KITTITAS COUNTY COMMUNITY DEVELOPMENT SERVICES

Subject: Determination of Complete Application
Lesh Preliminary Plat LP-09-0004

Your application for the Lesh Preliminary Plat was received on June 8, 2009, and has been determined complete on the date of this letter.

DWN BY: _____ DATE: 06/09 JOB NO.: 08115
CHKD BY: G. WEISER SCALE: 1"=200' SHEET: 1 OF 2
D. NELSON

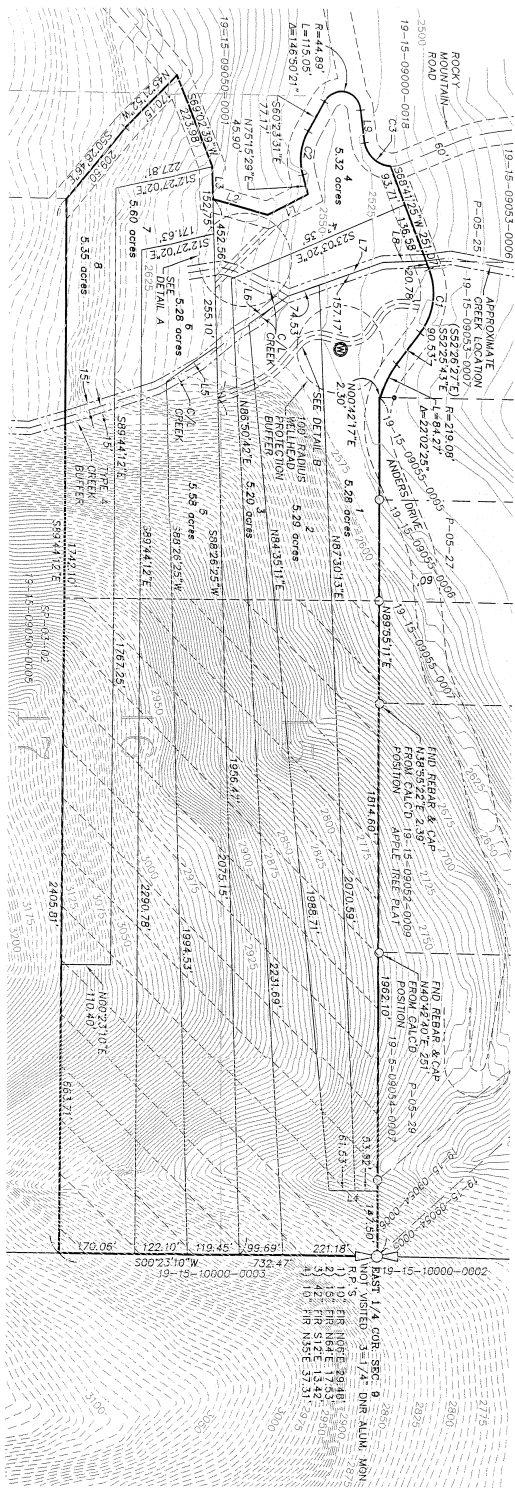
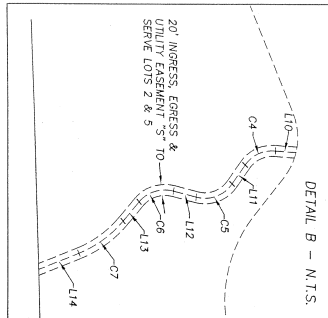
1. Kittitas County Road Standards require lots created on private roads serving more than 40 lots to have two accesses to county roads. Rocky Mountain Road currently serves more than 40 lots, therefore the lots proposed in the Lesh Plat must have a second access. According to the submitted SEPA checklist (Question 14.a), the proposed second access to the Lesh Plat is via an easement to be established across the Apple Tree plat to the north. This access easement has not yet been established and depends on the approval of a Plat Modification to the Apple Tree plat. This proposed second access is not shown on the submitted preliminary plat map. Please submit plans identifying a viable second access to the Lesh Plat and/or where one will be established in the future and the expected timing.
